Rezoning Transportation Analysis

Petition Number: 2020-066

General Location Identifier: Tax ID 21313828

Date	Description
5/18/20	First Review (MM)
6/26/20	Second Review (LJensen)

RZ-1.0

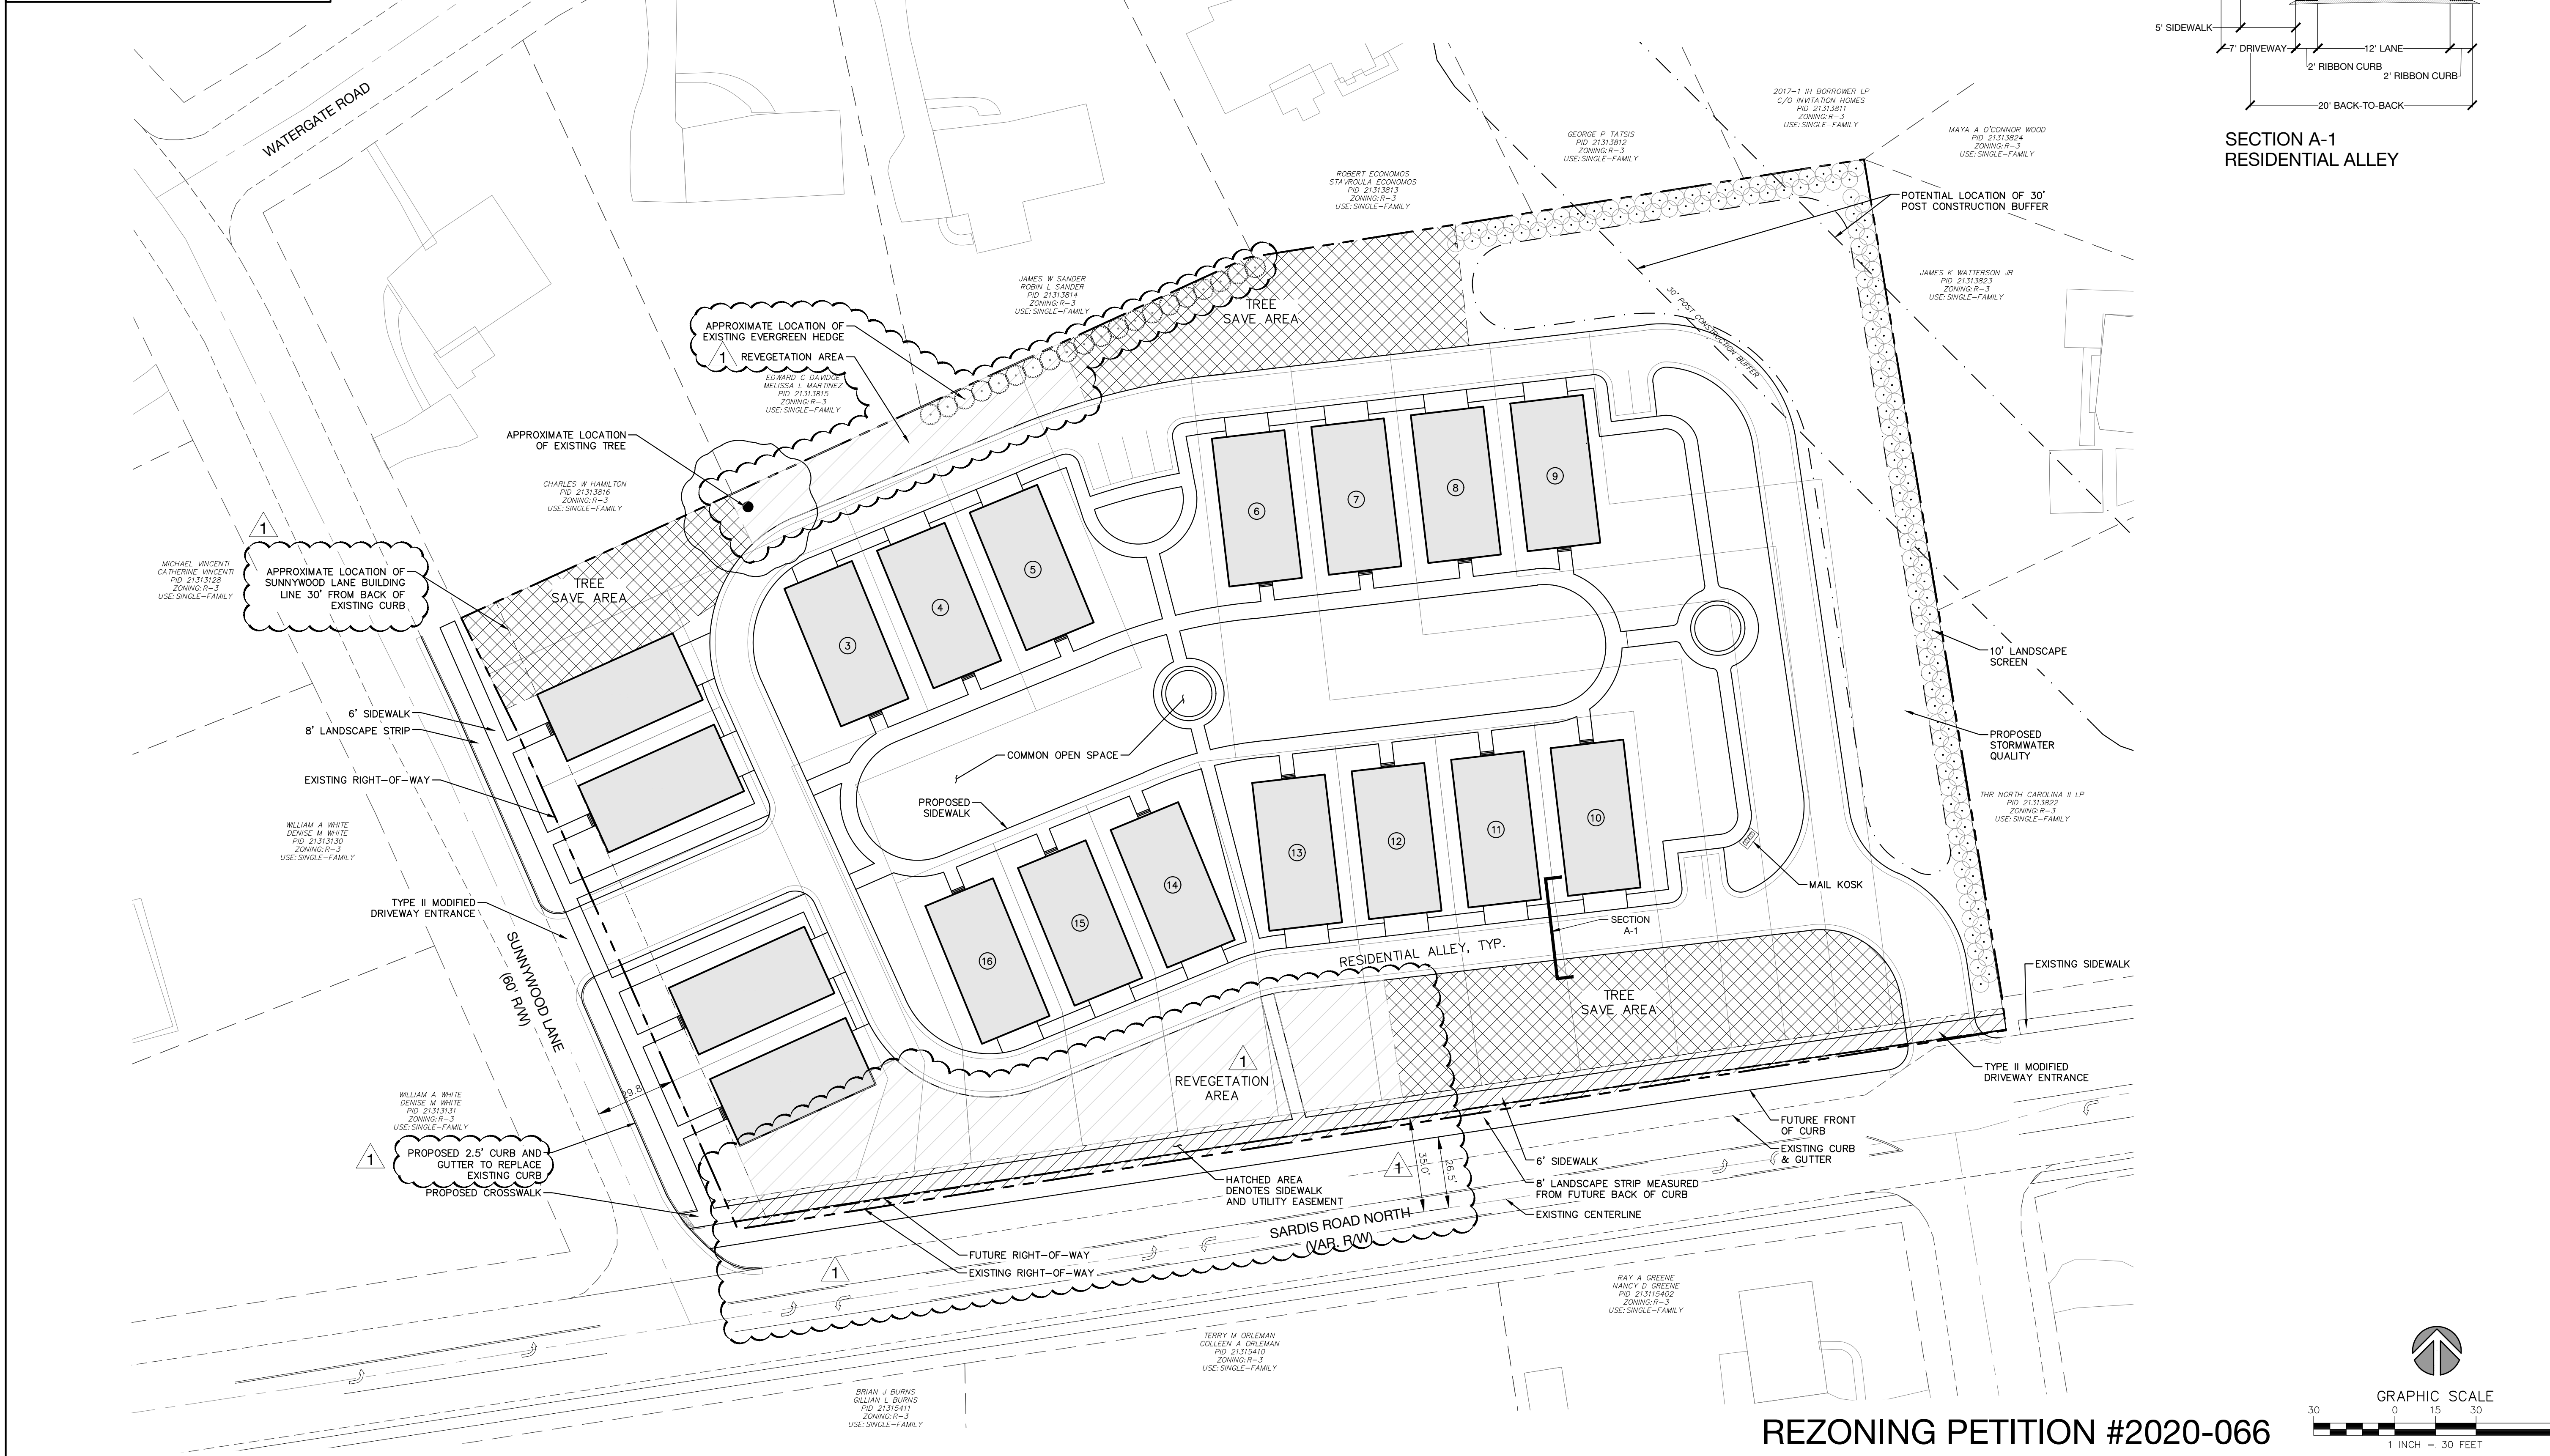
- ~~1. **Curbline** The proposed zoning district has a setback measured from back of the existing or proposed future curbline.
 - ~~a. **Sardis Rd. North:** The future location of curb and gutter needs to be 26.5' centerline to face of curb.~~
 - ~~b. **Sunnywood Ln.:** The future location of curb and gutter needs to match a residential medium cross-section.~~

The site plan should show the curb and gutter labeled and dimensioned from the centerline for each road.~~
